***MODIFICATION REQUEST:  
7 Railway Street, Chatswood  
MP09\_0154 MOD 1***

Director-General's  
Environmental Assessment Report  
Section 75W of the  
*Environmental Planning and Assessment Act 1979*

April 2012

Figure 3 – Revised wind mitigation strategy
Source: Windtech Pty Ltd

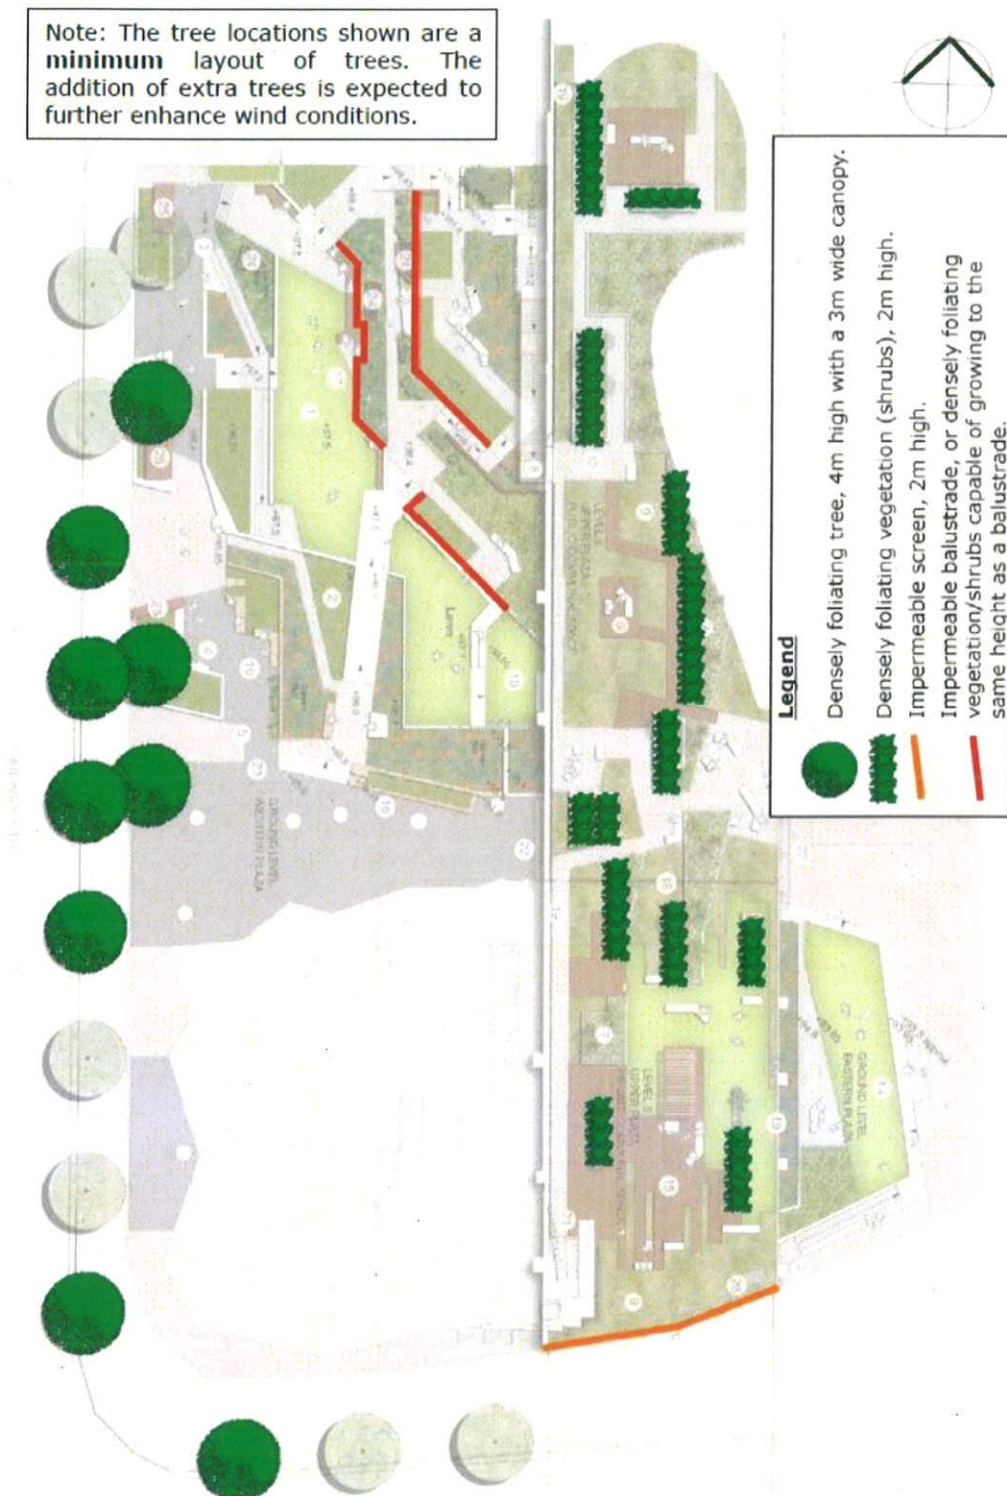
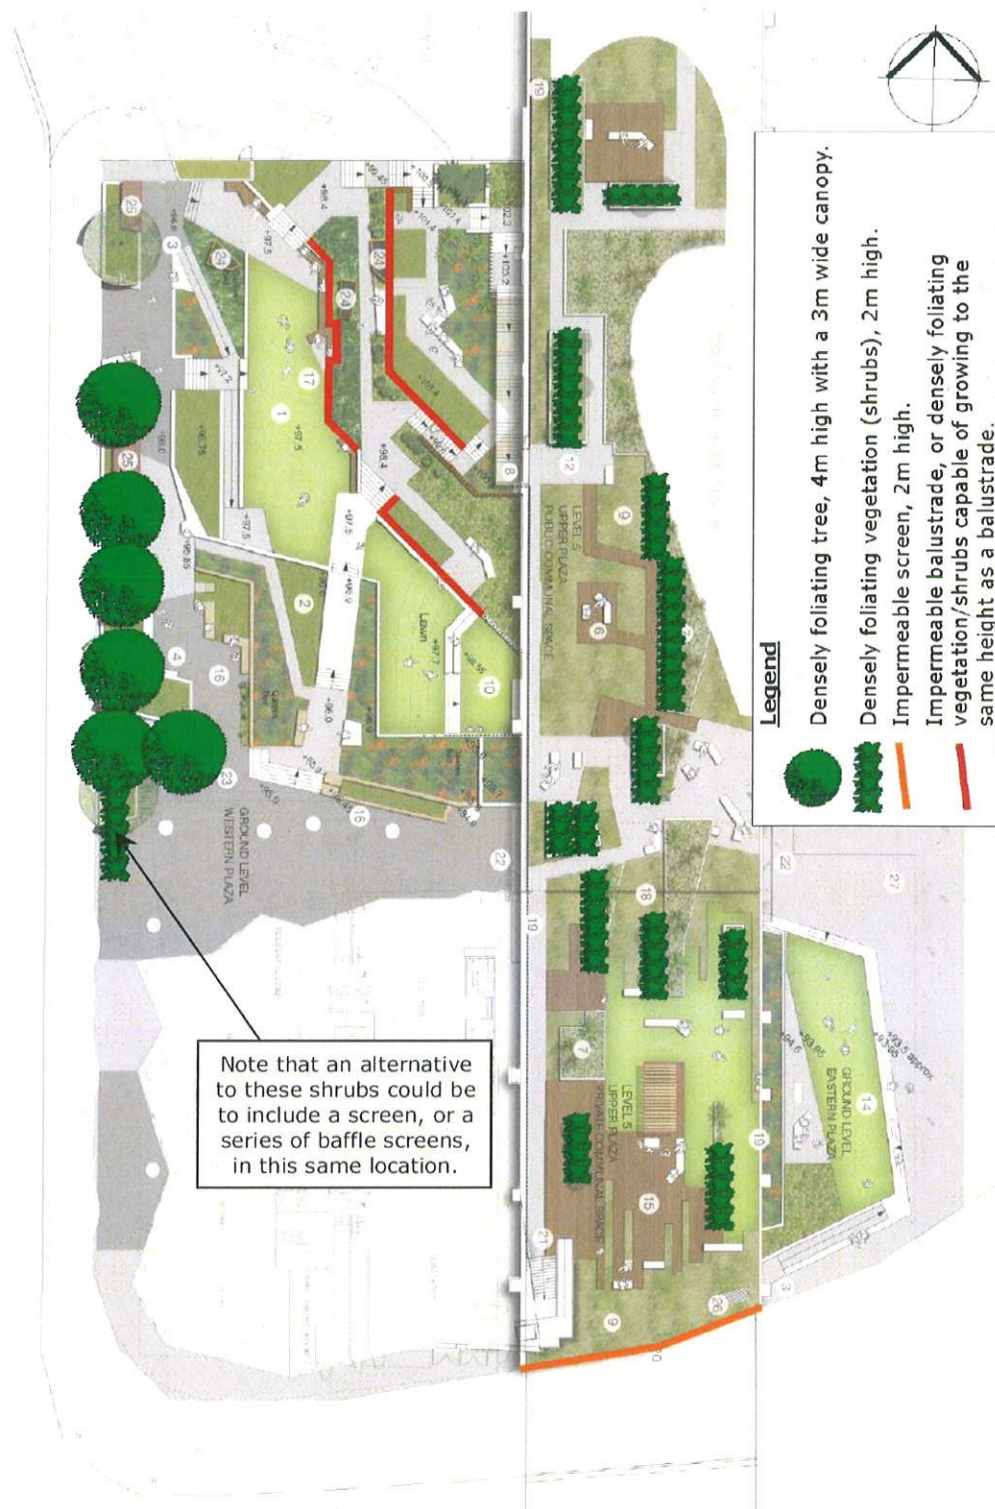
In addition, a supplementary Wind Statement has been provided confirming that the marginal exceedance of comfortable wind conditions at the corner of Railway and Help Streets is not exacerbated by the development and that mitigation measures are not warranted in this location.

In the absence of street trees, the post development wind conditions in this location are estimated to be 7.8m/s. This is an improvement to the current conditions and continues to comply with the Lawson criteria. The wind conditions, however will not meet the more stringent Davenport criteria for slow walking.

On this basis, the deletion of the requirement for street trees (Condition E17) is considered acceptable with replacement trees provided within the property boundary.
